**Re: New development for Nusenda Credit Union at 6401 Uptown Blvd NE, Abq NM.
Transportation Development comment responses:**

Below please find responses to the comments from Marwa Al-najjar in a letter dated November 7, 2025. The comments have been addressed on the updated Site Plan sheet A001 and A002 with revision dates 11-10-2025.

SITE PLAN

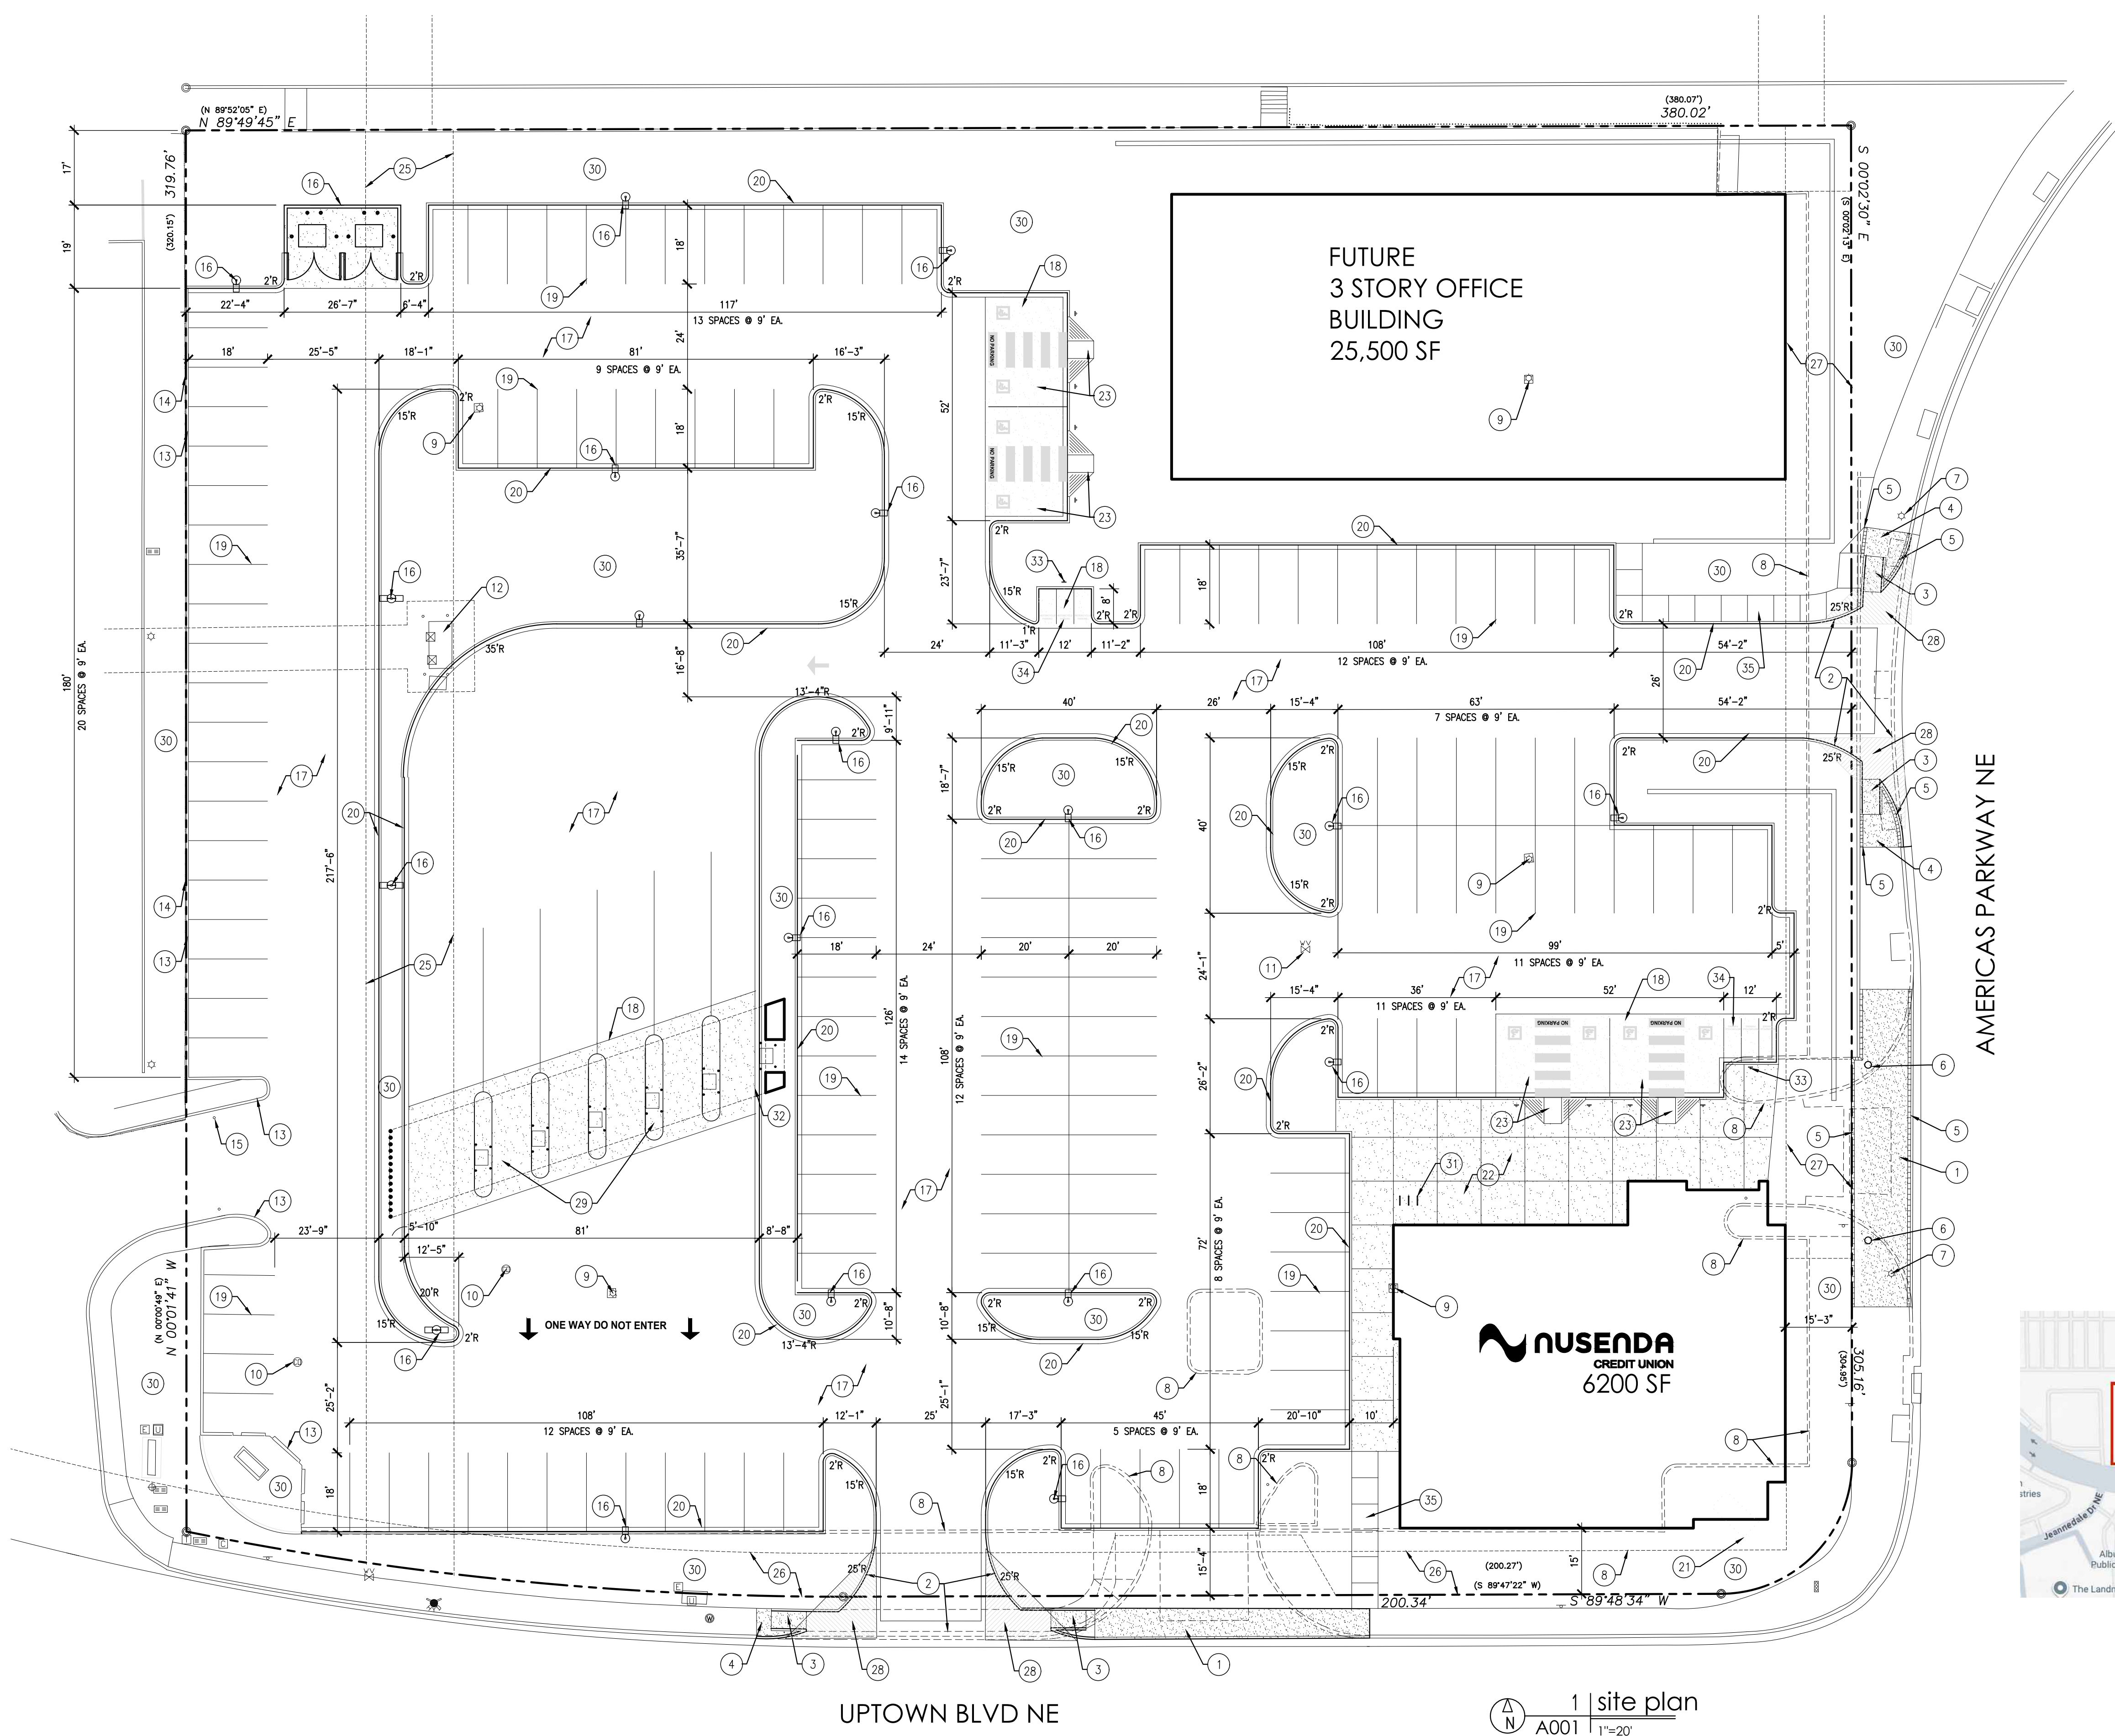
1. Comment 1: The number of spaces required as well as the number of spaces provided are shown on the Site Data on the right side of sheet A001 under Parking Calculations. The list has been updated to show ADA requirements. It was determined that 108 parking spaces requires 4 motorcycle parking spaces, so two spaces were added for a total of 6. Bicycle parking is listed and is adequate. The bike rack detail has been designed to meet DPM requirements.

2. Comment 2: The street ROW widths, medians curb cuts and street widths have been added to the site plan.
3. Comment 3: The cross-access agreement for the existing driveway at the southwest corner will be provided as a condition of releasing the C.O.

4. Comment 4: Per DPM Section 7-4(K)(20)(5) the queuing widths are required to be 12' wide min. the site plan shows 13' width.
5. Comment 5: Keynotes 39, 40, and 41 have been added to the site plan which refer to details 13/A002 and 14/A002.

6. Comment 6: Keynote 3 has been added at the southeast corner ramp to be replaced with compliant ramp.
7. Comment 7: a radius width of sidewalk has been added at the fire hydrant location with keynote 42.

8. Comments 8: the clear sight triangles at both new driveways have been moved on the site plan to the back of the sidewalk.
9. Comment 9: Stamped approved site plans from Solid Waste and Fire Marshal are included with this submittal.
